12 Jerome Way, Shipton On Cherwell, Kidlington,
OX5 1JT

23/00777/F

Proposal: Single storey side extension, front porch extension, part two storey and part single storey rear extension together with associated internal and fenestration alterations

Drawing Title
 PROPOSED FIRST FLOOR
 & ROOF PLAN

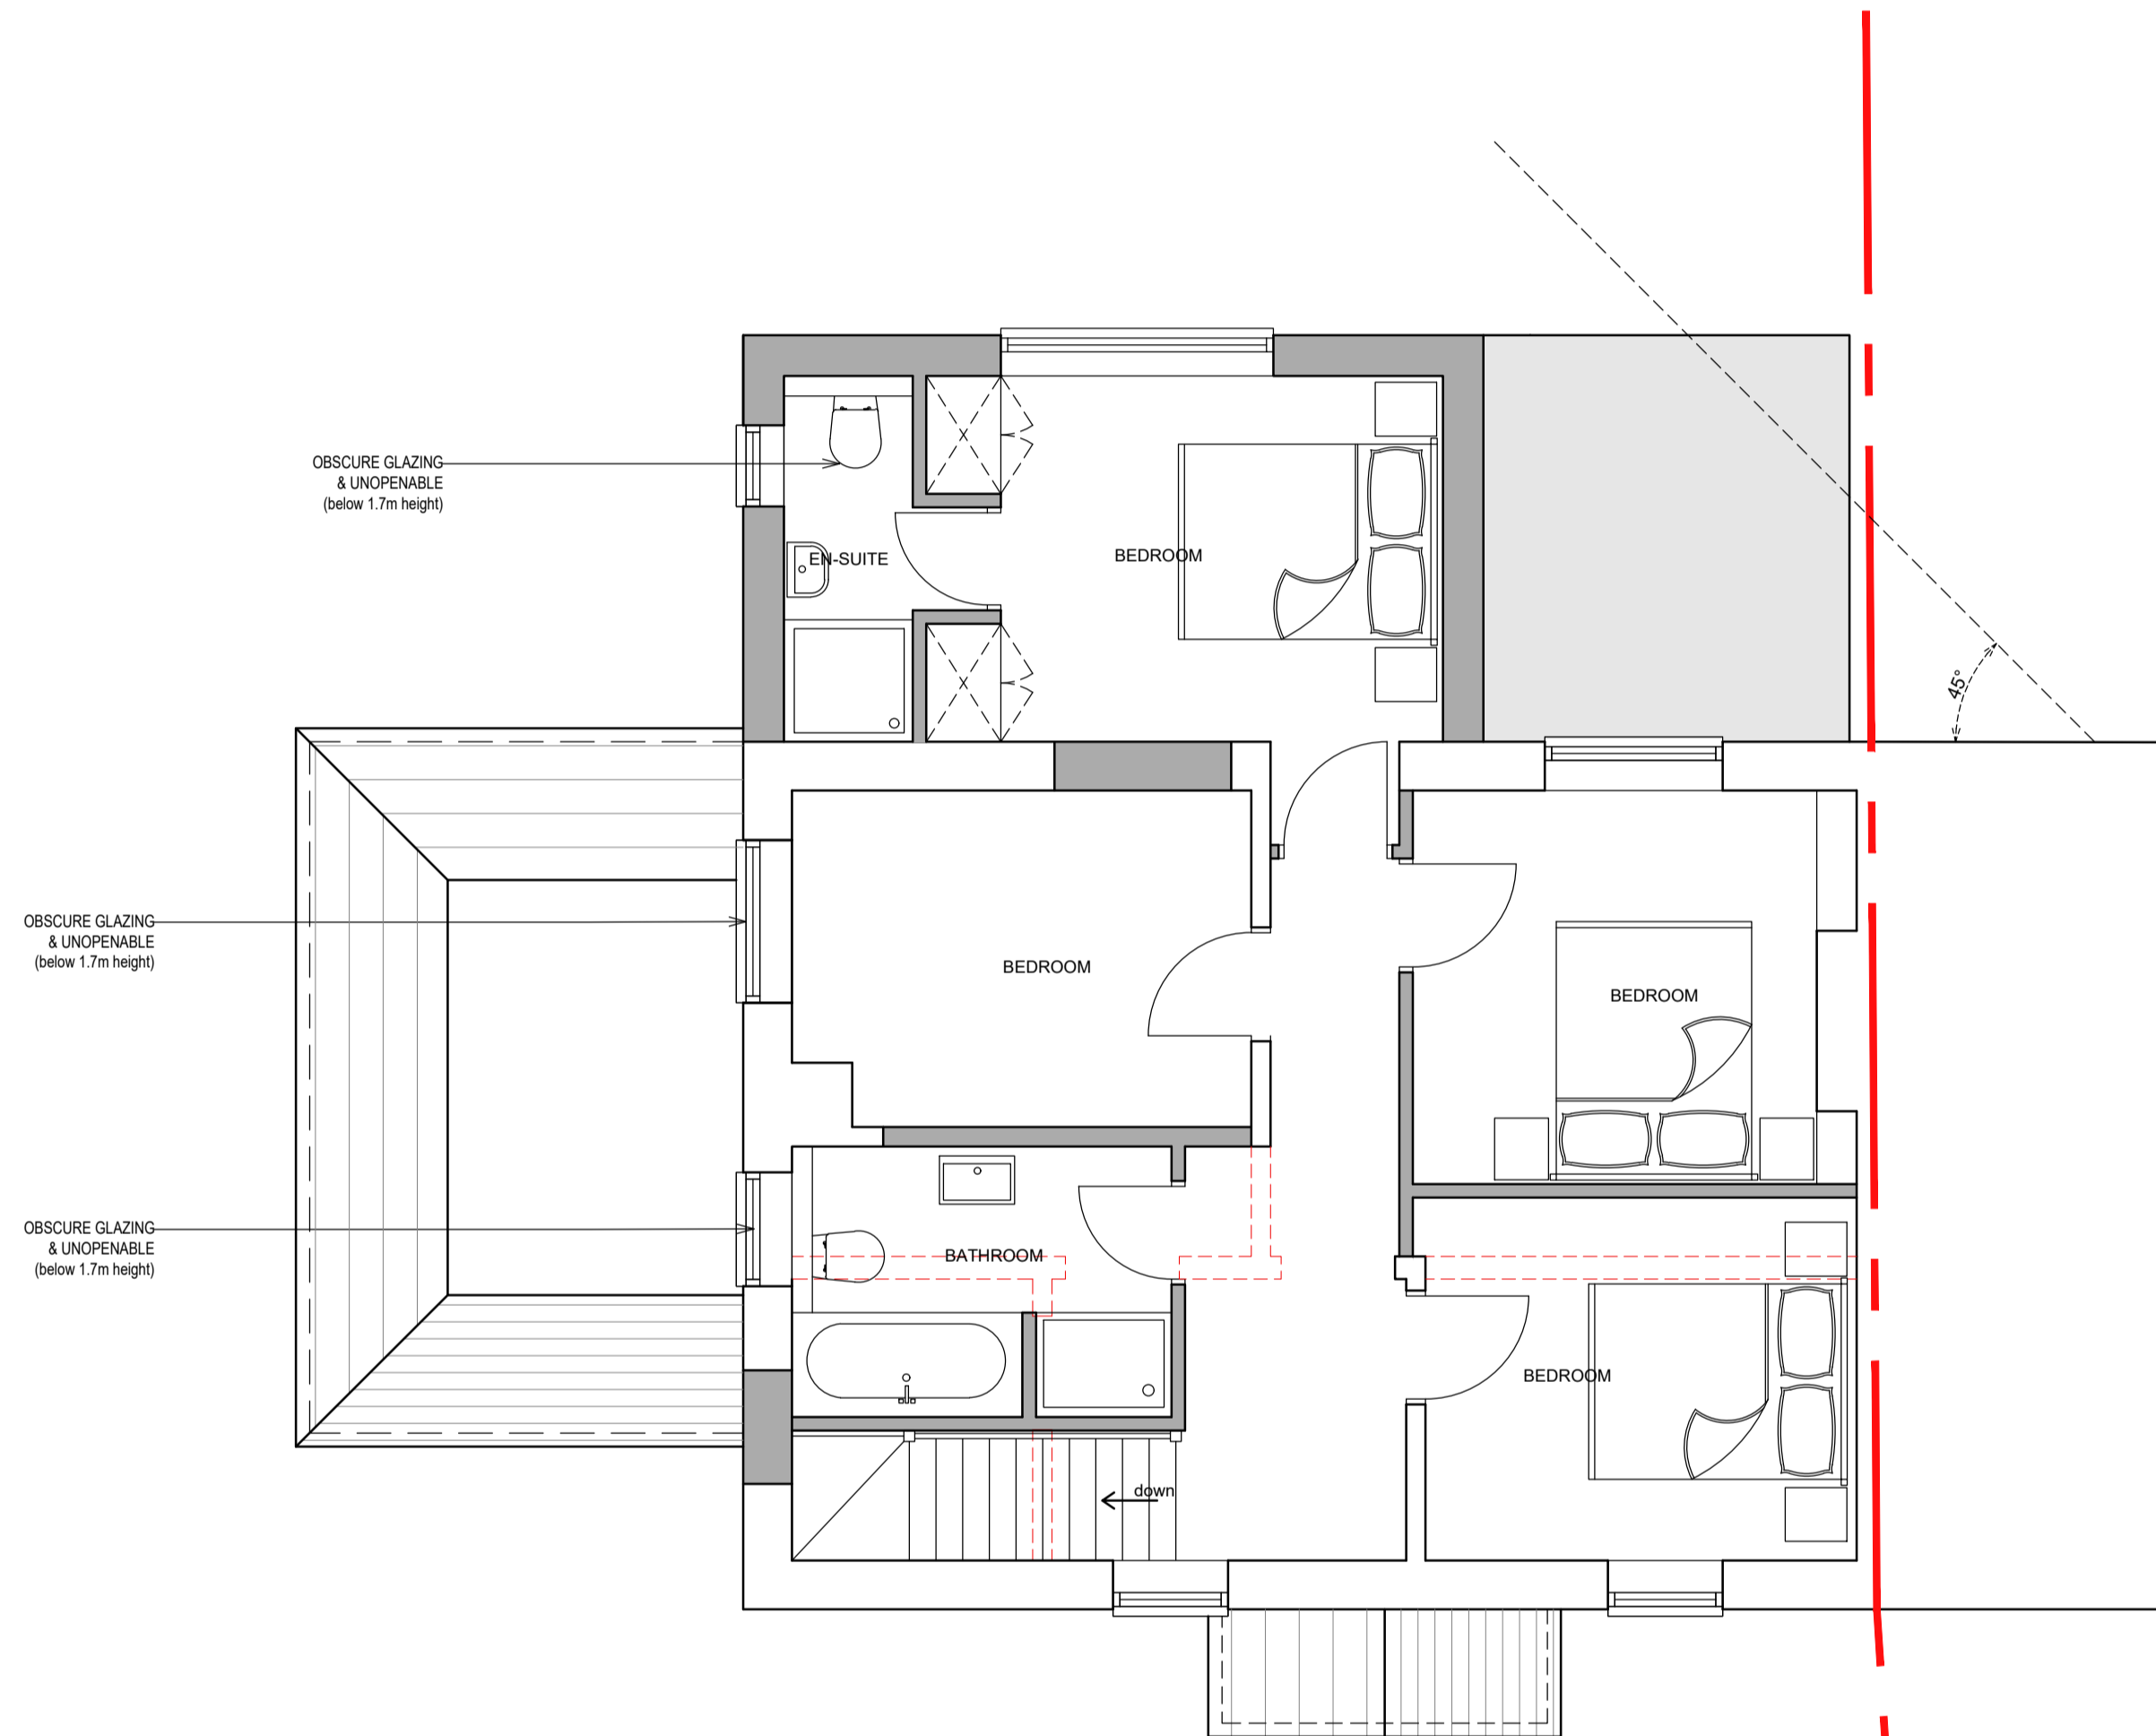
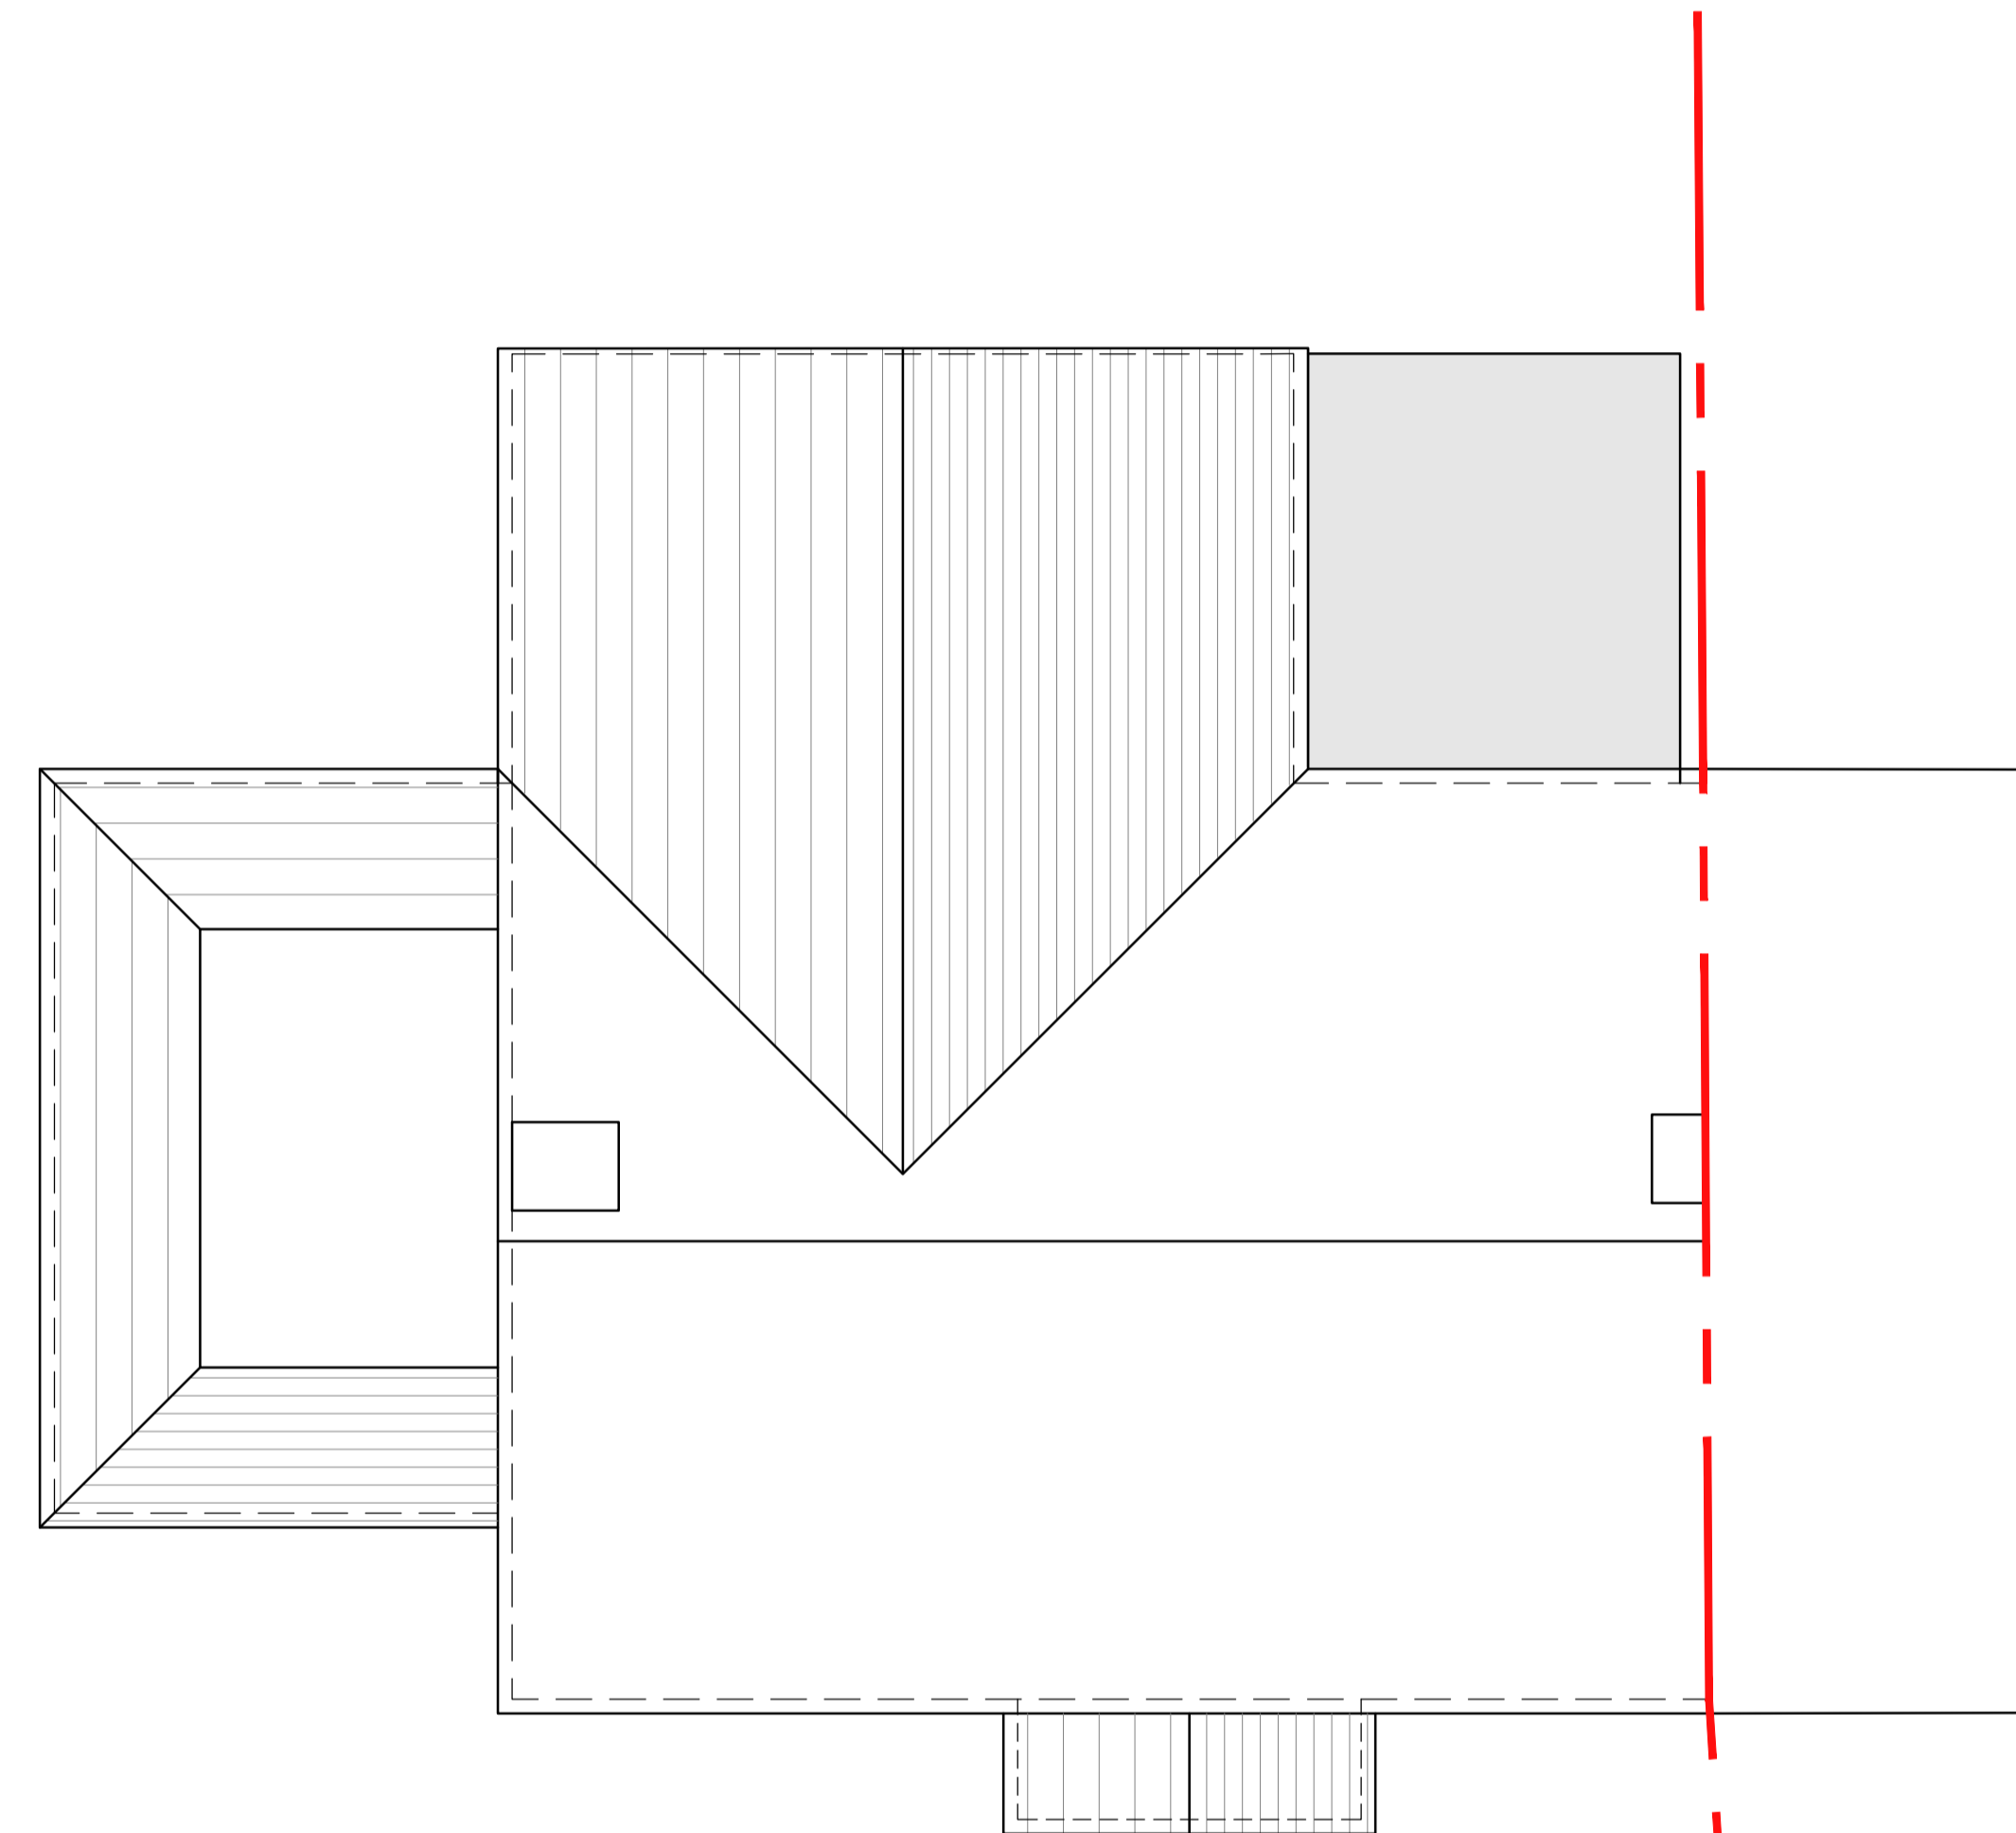
The proposal will include four windows and one door on the side elevation. This includes one door and one window on the ground floor, leaving three windows on the side elevation of the first floor. The window on the rear extension would serve an en-suite bathroom, with the two windows on the existing dwelling serving a bedroom and bathroom respectively. All three windows on the first floor are shown on the submitted plans to be of obscured glazed and non-opening. This will be conditioned to protect the neighbouring residents' amenities.

The proposed two storey extension does not contravene the 45 degree line with windows in the attached neighbouring property and is therefore considered to be acceptable in this regard. The single storey side and rear extensions are considered acceptable by virtue of their size and location as it would not adversely impact the amenity of the adjoining neighbour.

3. The three windows on the first floor of the side elevation shall be obscure glazed, using manufactured obscure glass that is impenetrable to sight, (not an applied adhesive film) before the extension is first occupied and shall be permanently retained as such thereafter. The window shall also be non-opening, unless those parts which can be opened are more than 1.7m above the floor of the room in which it is installed and shall be permanently retained as such thereafter.
